Application No: M/91/21/PL
Site Address: 27 Central Drive Middleton-On-Sea PO22 7TT
Description of works: Variation of condition 2-approved plans & removal of condition 4-materials included on plans imposed under M/25/19/PL.

Thank you for your internet representation made on 22nd July 2021 which has been recorded as an objection with the comments as follows:

PROJECT	27 Central Drive - Elmer Beach	DATE	16/09/18
TITLE	Proposed South Elevation	DRG NO	IBA/507/05
SCALE	1 : 50	REVISIONS	B

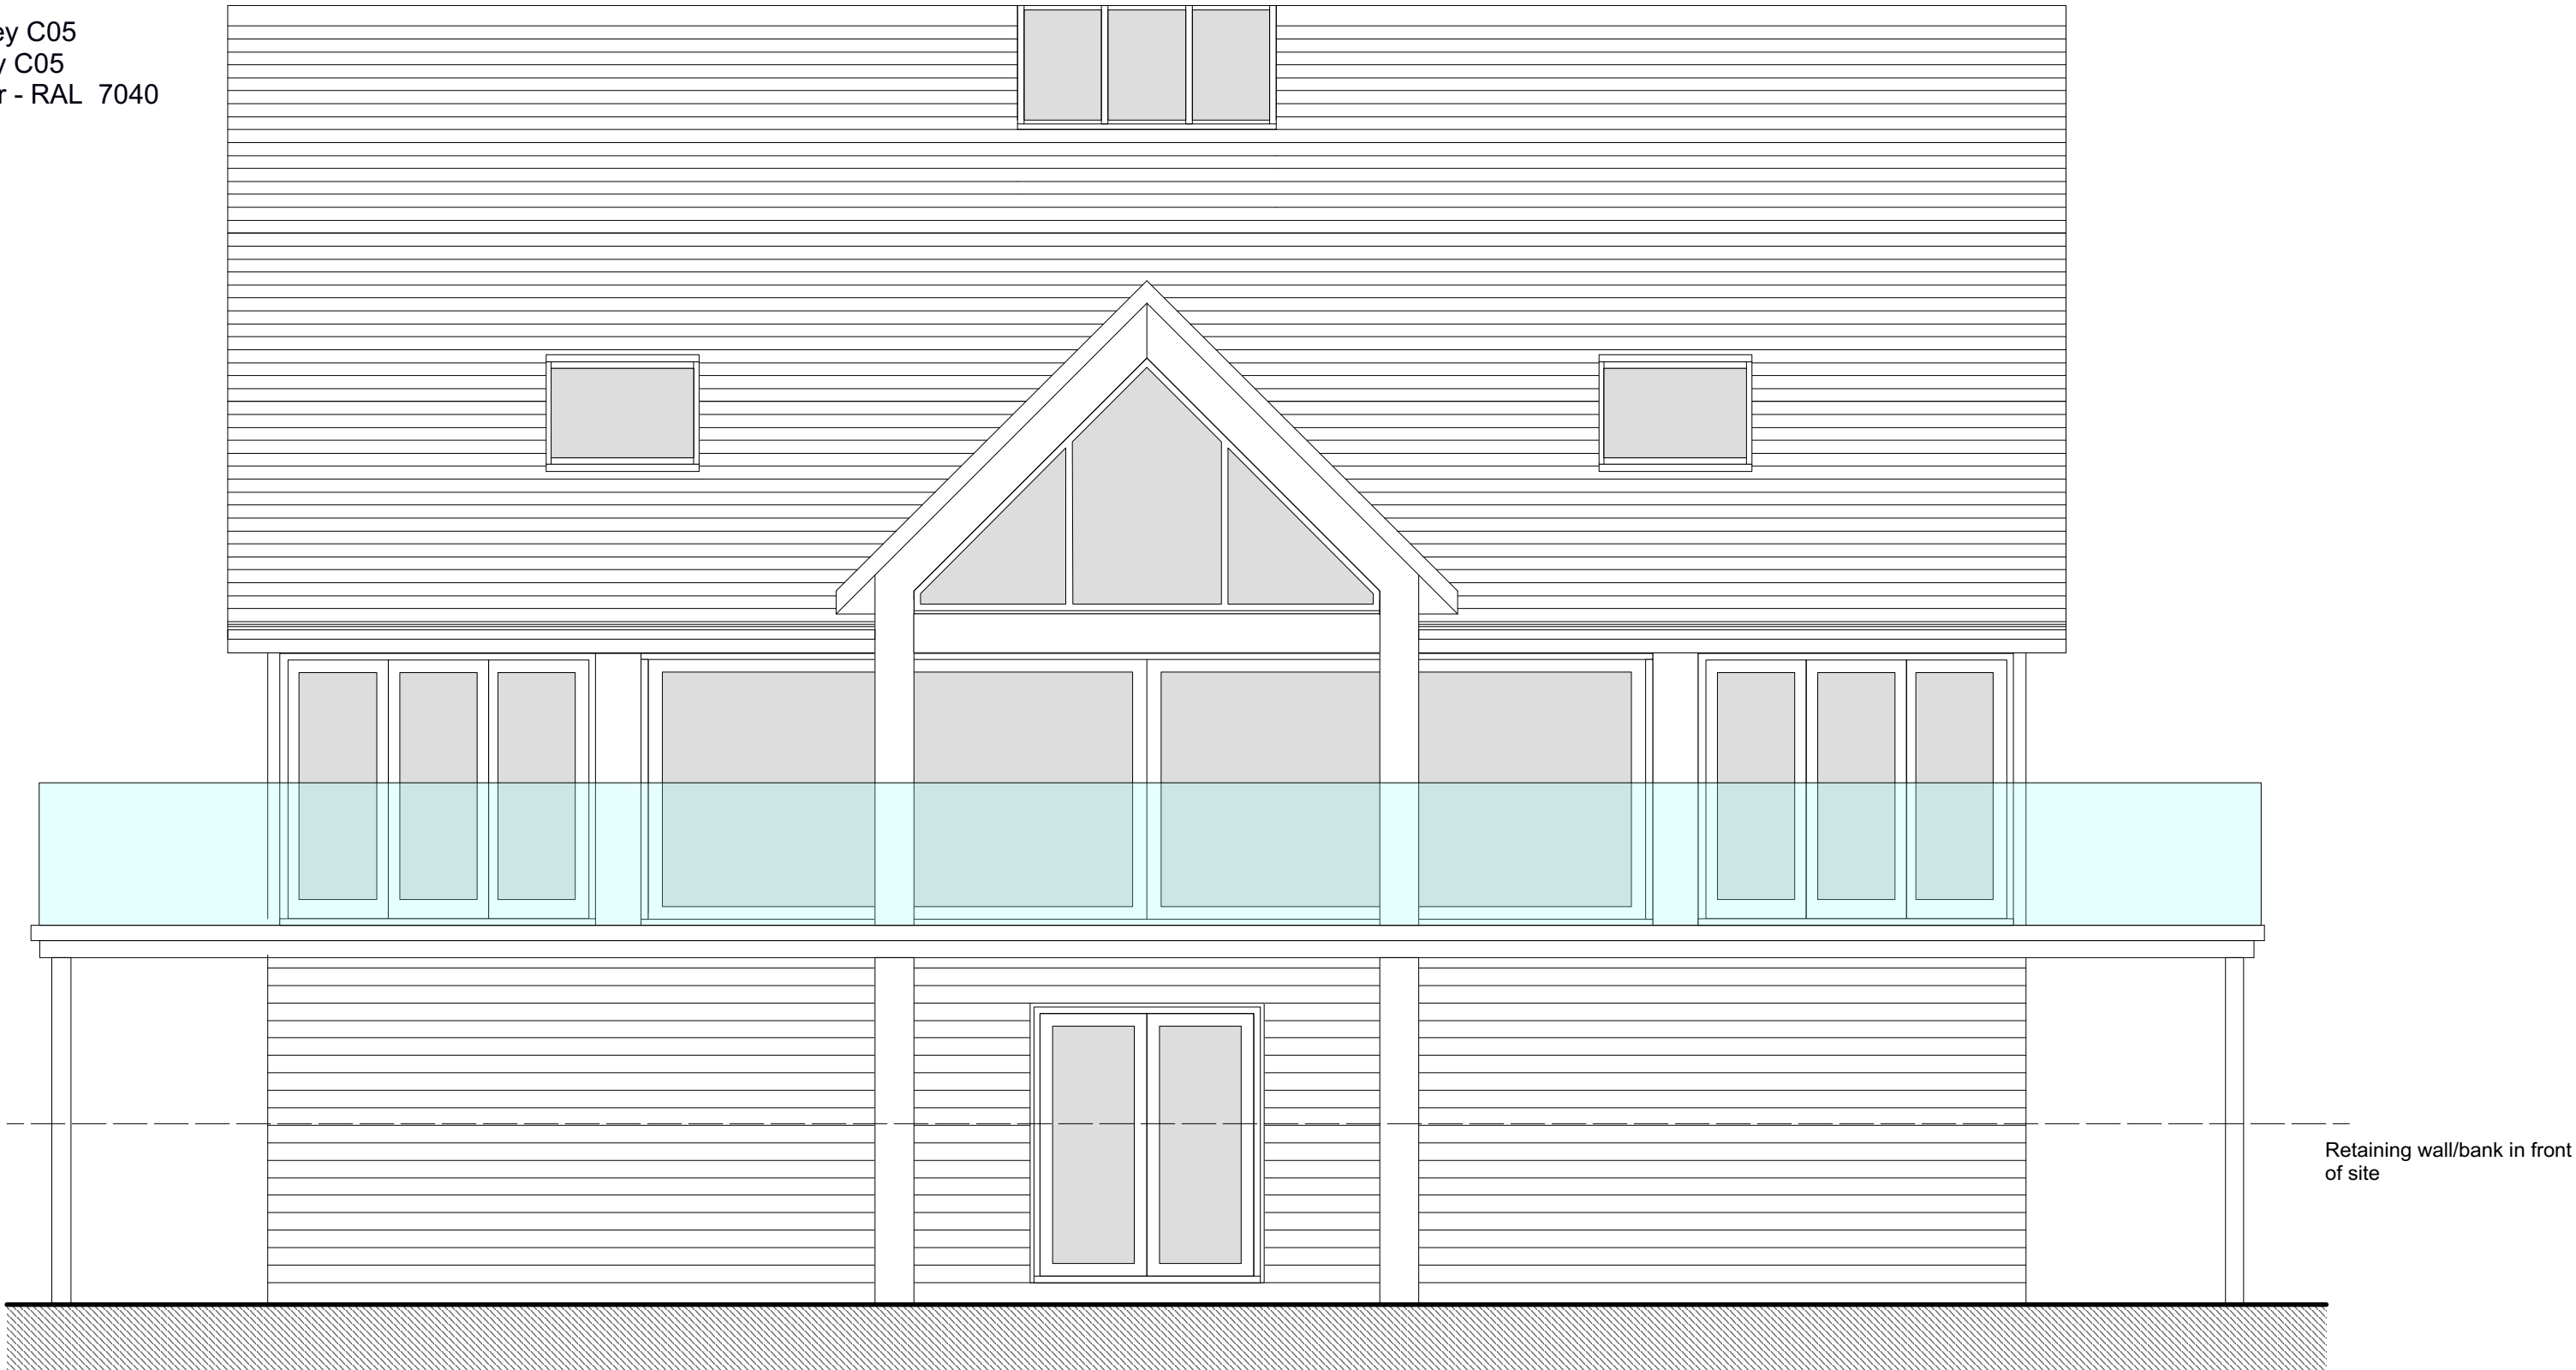
We wish to object most strongly against this proposal. We feel the structure is grossly out of keeping with the adjacent properties along the back of our favourite beach, IN particular there is an issue of non compliance the drawings, the roof line of the new property being much higher than adjacent properties.
